Recommendation Report for Prior Notification for Householder Extension

REF NO: BR/99/18/PDH

LOCATION: 60 Chichester Road
Bognor Regis
PO21 2XL

PROPOSAL: Notification under extended permitted development rights for a single storey rear extension measuring 7m beyond the rear wall of the original dwelling house, with a maximum height of 3m & an eaves height of 2.8m.

Existing House Layout

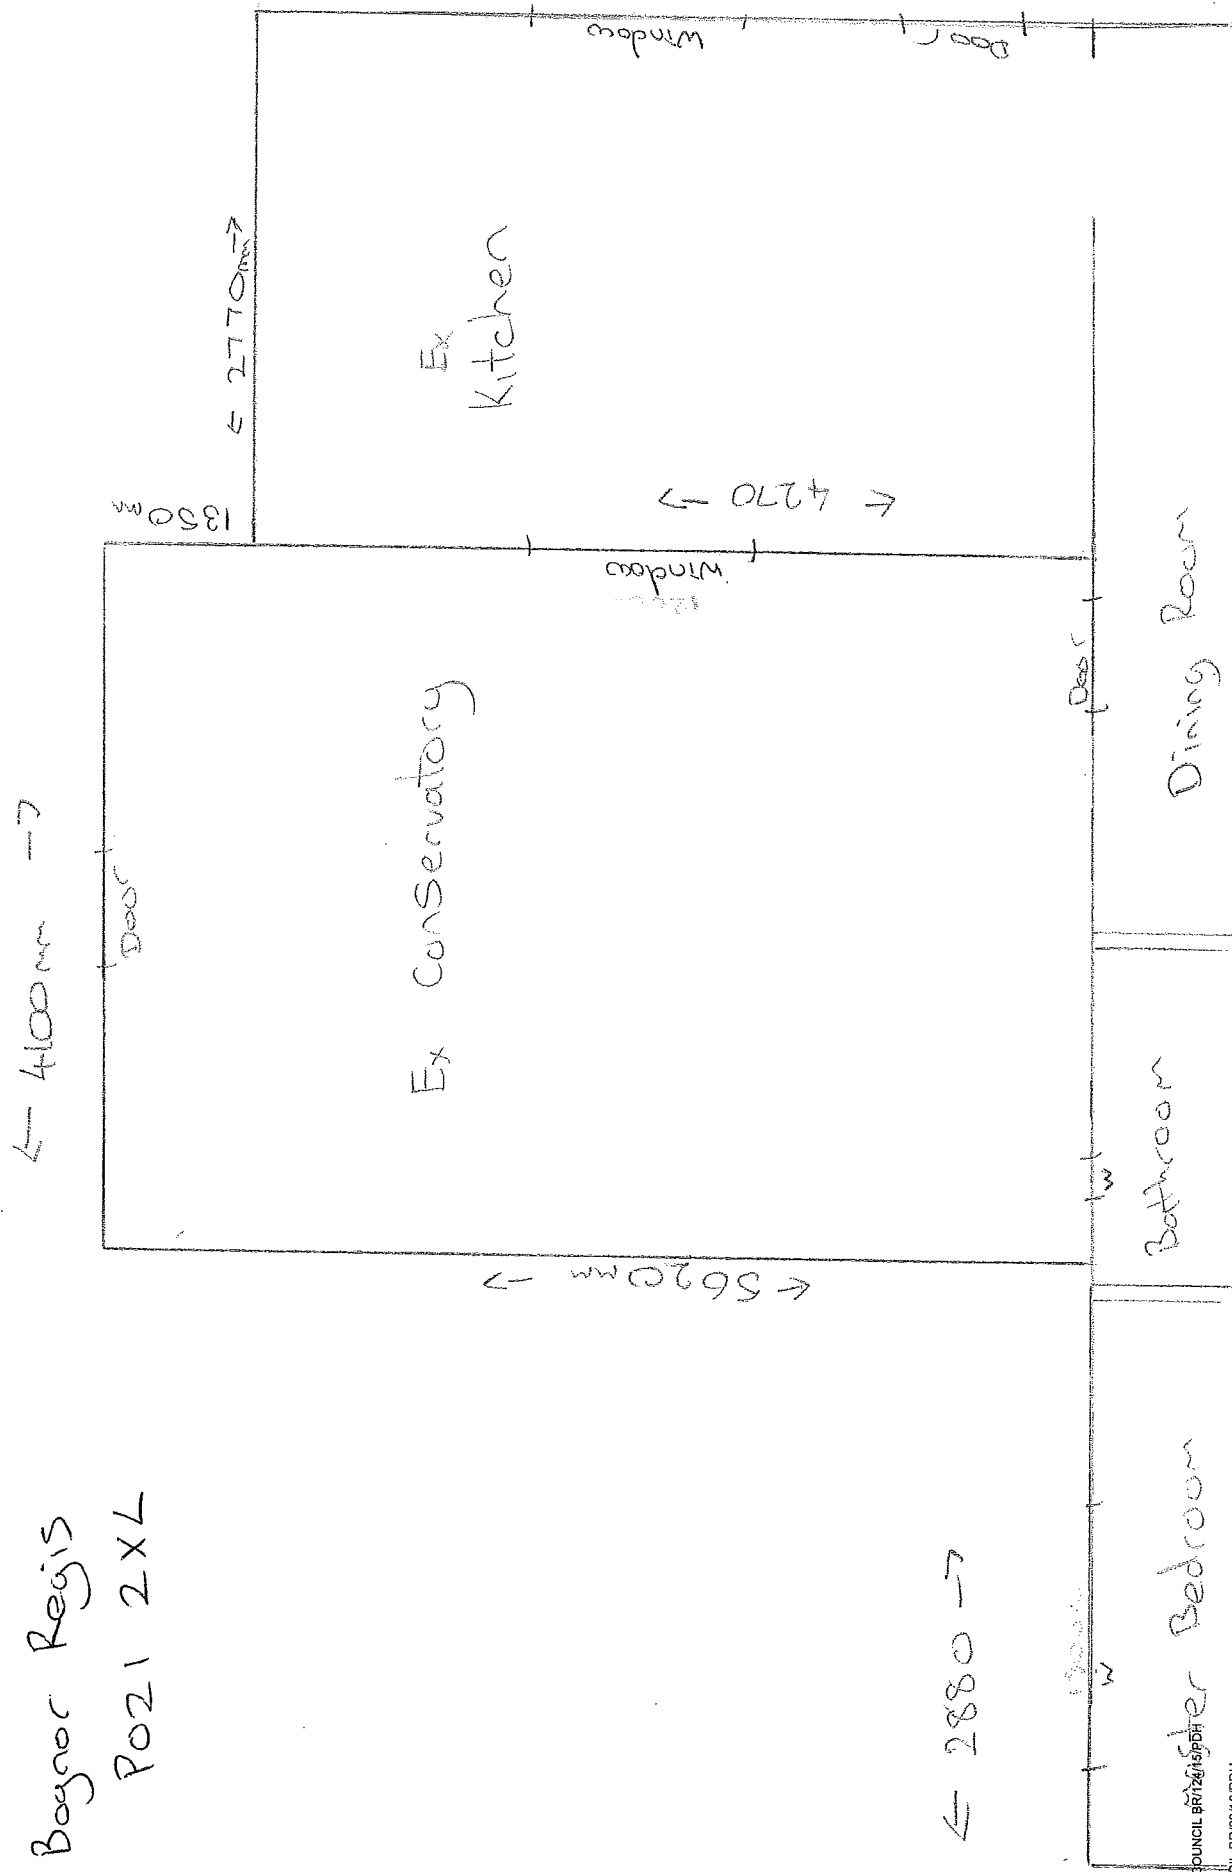
Schedule 2, Part 1, Class A - (j)(iii) The enlarged part of the dwellinghouse would extend beyond a wall forming a side elevation of the original dwellinghouse, and would

- (i) exceed 4metres in height
- (ii) have more than a single storey or
- (iii) have a width greater than half the width of the original dwellinghouse.

The proposed development extends beyond the rear of the dwellinghouse by 645mm and has

a width greater than half the width of the original house.
